**Re: Major Project Application No. MP 08 0034 – Proposed 62 Lot Subdivision, Commercial Building and Manager's Residence at Lots 2 and 3 DP 244652 Uriup Road, Bilambil**

**Re: MP08-0034 Proposed 62 Lot subdivision, commercial building and manager's residence at Lots 2 and 3 DP244652, Uriup Rd Bilambil**

**Re: Proposed development of Lots 2 and 3 DP244652 Uriup Road Bilambil, MP08\_0003.**

John Sherwood for
JACKSON INTERNATIONAL Pty Ltd
Bilambil Residential Estate
Bilambil Road Lots 2 & 3 DP 244652 BILAMBIL, NSW
LANDSCAPE CONCEPT PLAN
A1.DD.2 March 2009

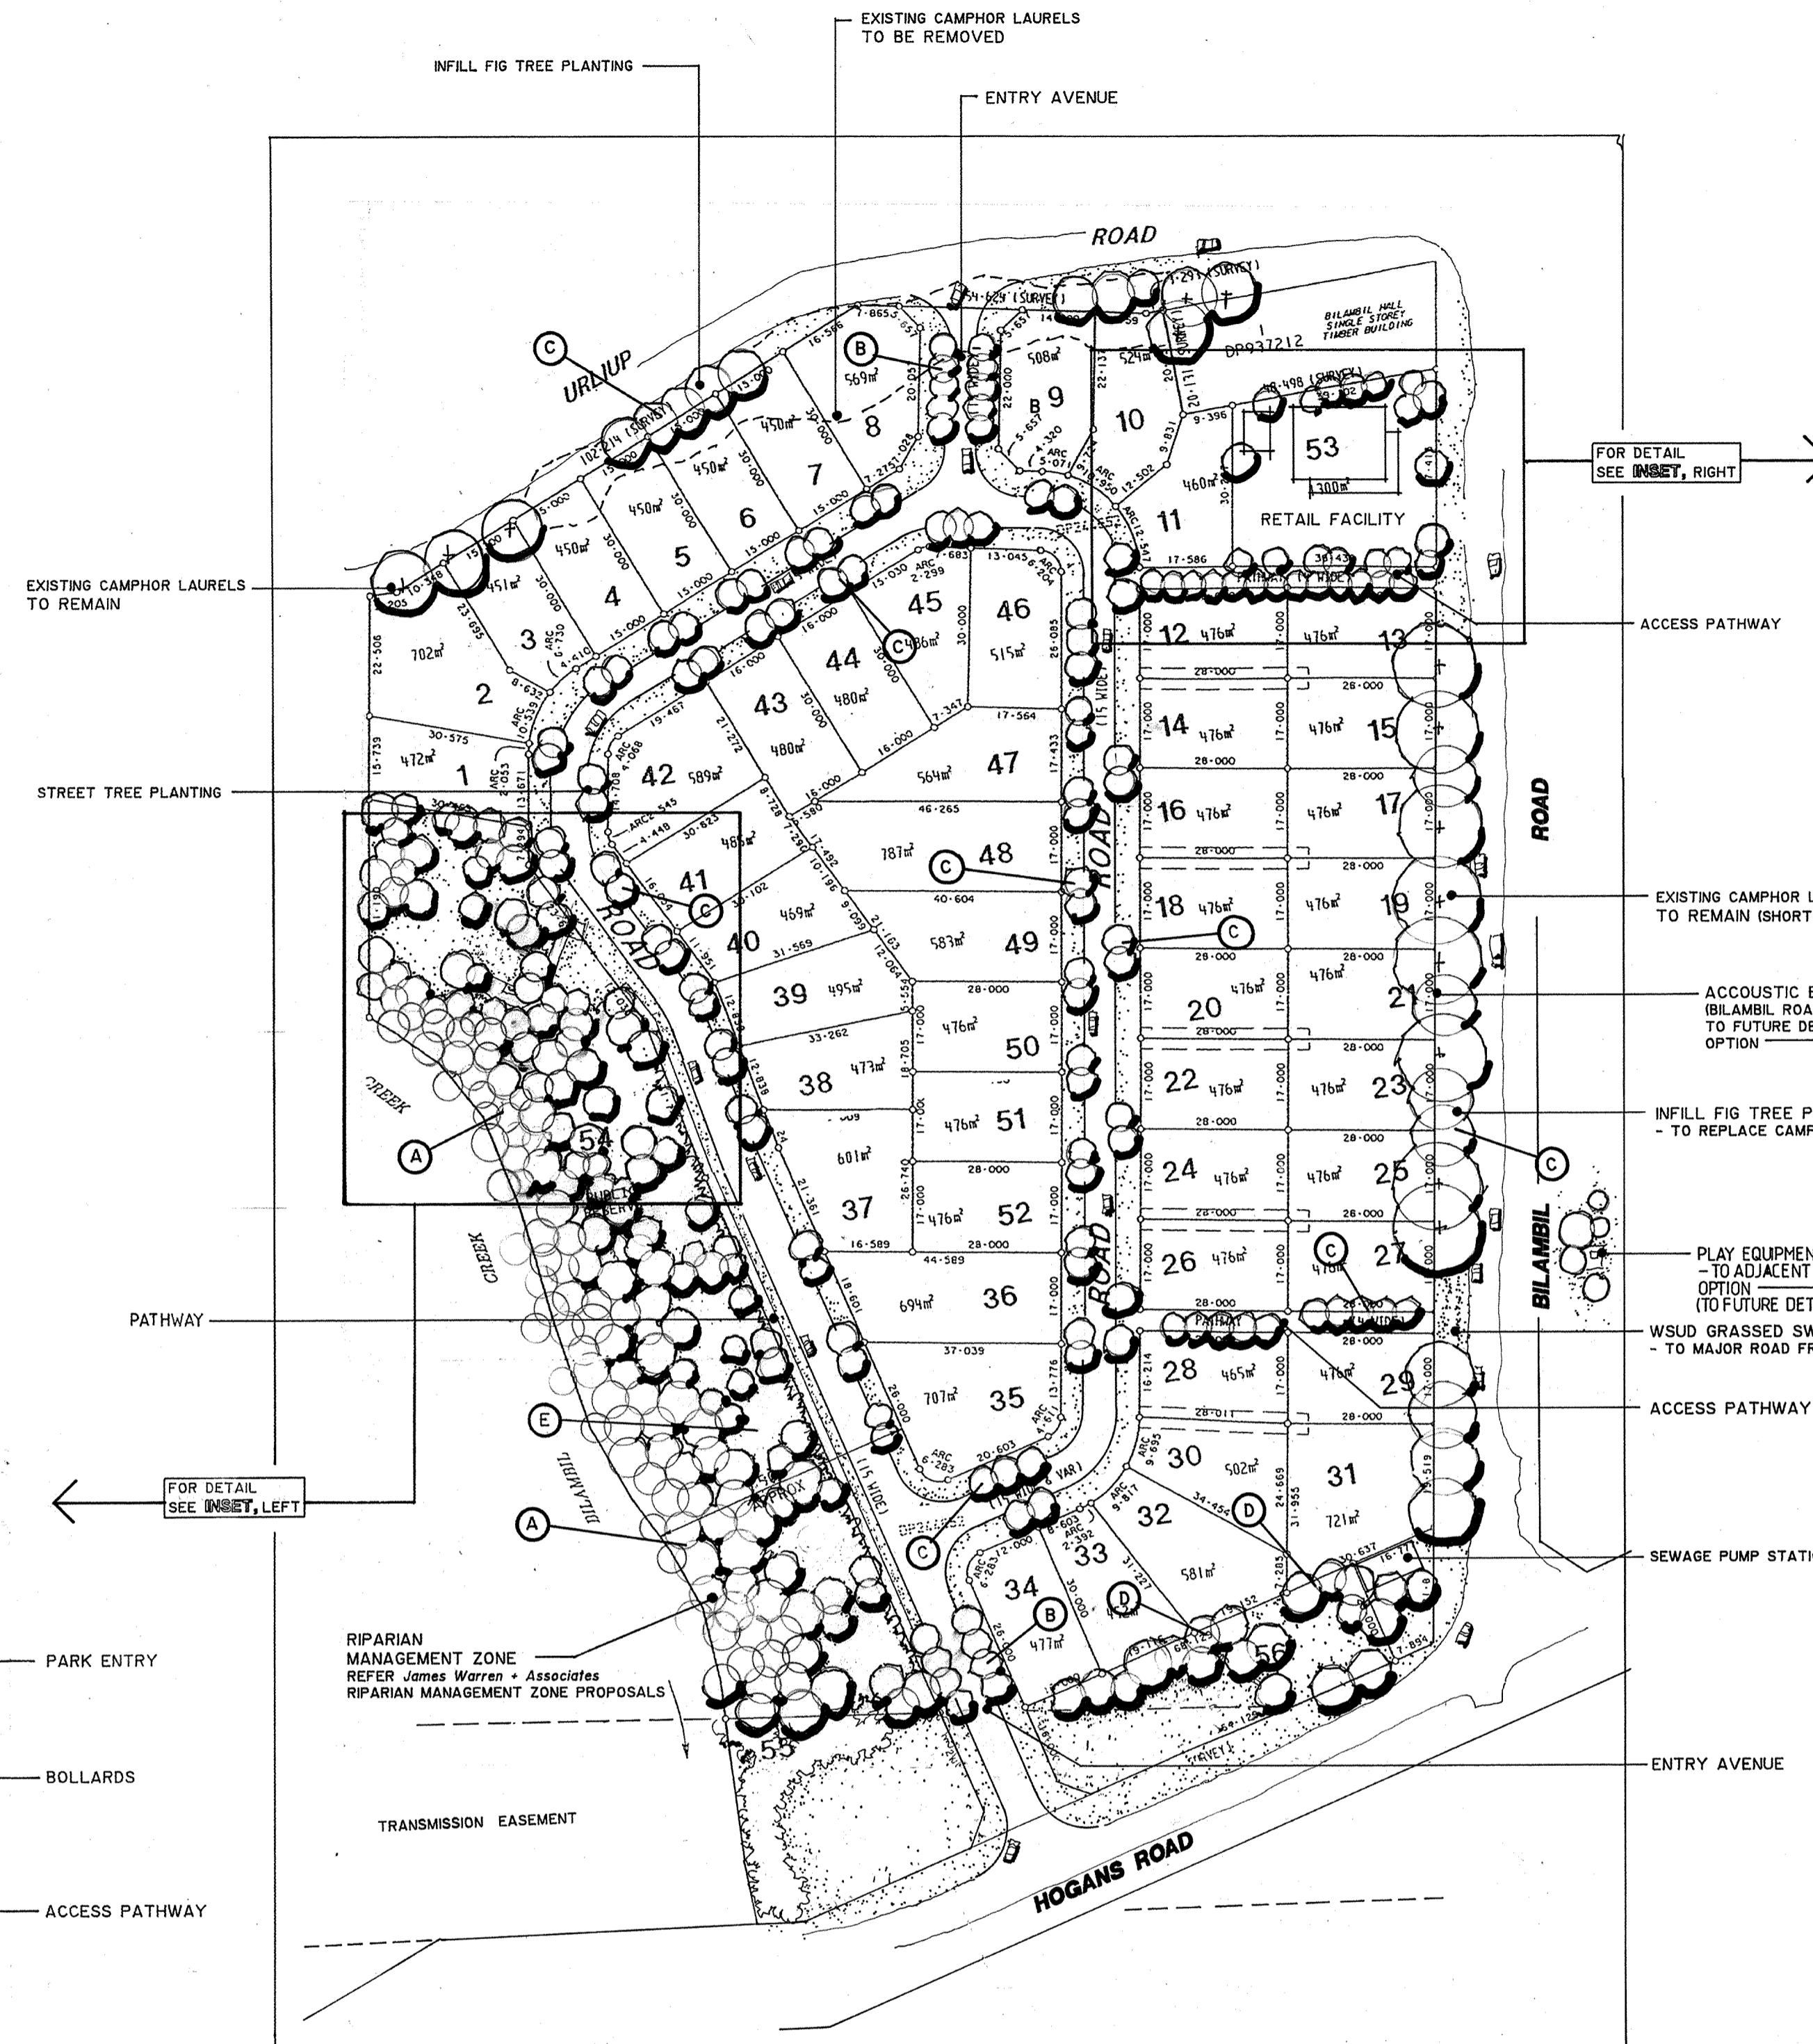
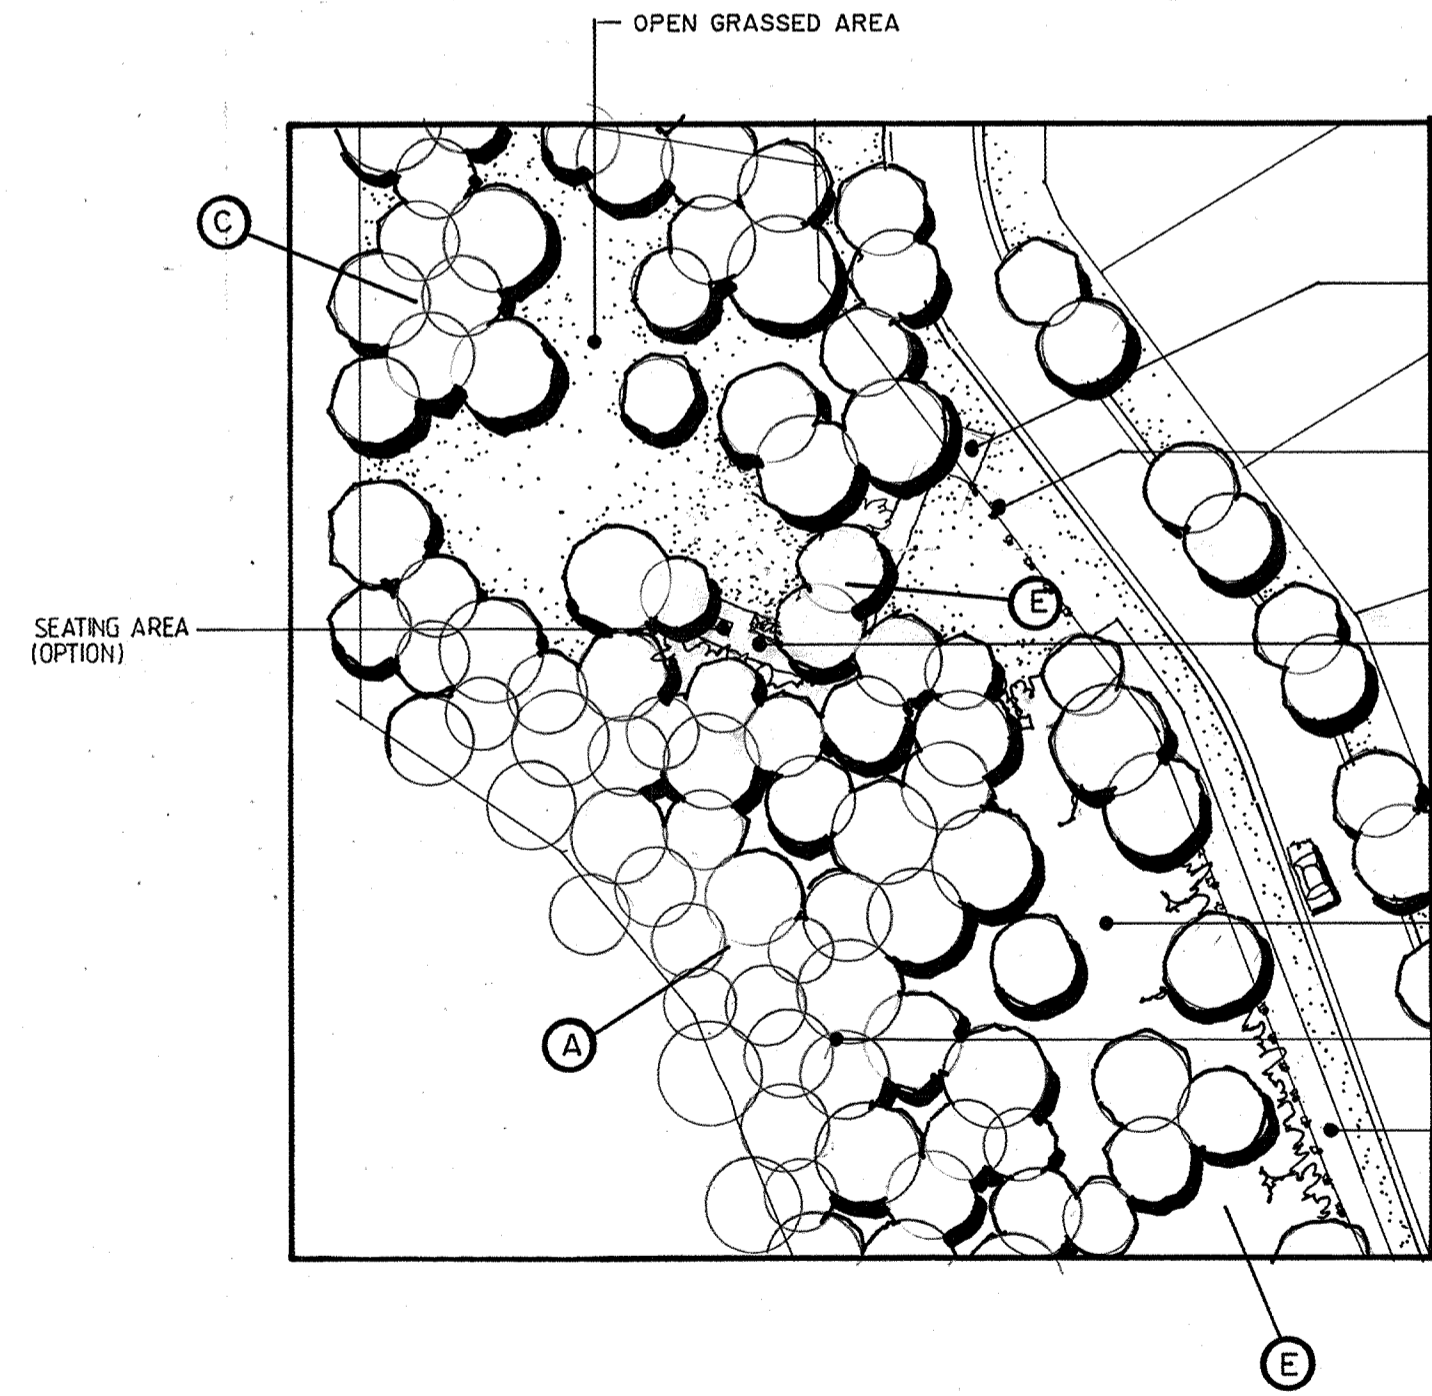
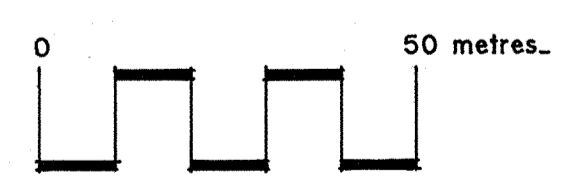
- Review of the new lot layout shows that the proposed development still only provides a 20m buffer between the lots and Bilambil Creek; however it is noted that one lot that previously adjoined the creek has been relocated to provide a continuous public reserve along the foreshore area. As previously stated, the Department recommends a 50m buffer to the creek to provide adequate space for rehabilitation and public access.

- Review of the proposed 20m creek side reserve arrangement supported by Council identifies a number of issues including the following.
  - The diagrams provided show the location of the public walkway within the 20m buffer zone to Bilambil Creek despite Council stipulating that recreational and engineering structures should be wholly outside this zone. Council has also advised on 15/12/2008, that a number of other agreed actions have not been included within revised plans.

- The creek side rainforest revegetation treatment identifies the area immediately adjoining the proposed lots to be rehabilitated with "low closed plantings of shrubs, forbs and ferns". Whilst a species list was not provided, it is unlikely that such vegetation structure would constitute a rainforest and it is unknown whether a rainforest community will indeed become established in this area. As such additional asset protection may be required in the future if an alternative vegetation type becomes established, however, this has not been catered for in the proposed development.

- Consideration of the above matters suggests that it may be more appropriate to relocate the road identified as Road 2 to provide a buffer between the rehabilitation and open space area and any proposed lots.

- The small area of open space provided along Hogans road would provide limited opportunities for public use and enjoyment and may be better positioned along the creek to enhance this area of open space. The stormwater retention basin could be located within this area to ensure consistency with Councils requirements that the retention basin be located greater than 20m from Bilambil Creek.

- A pedestrian connection between the creek and Uriup Road may enhance public access to the creek side public reserve.
- Any works associated with stormwater discharge which are proposed to be located within Bilambil Creek require the consent of the Department of Lands and application for such works will need to be made.
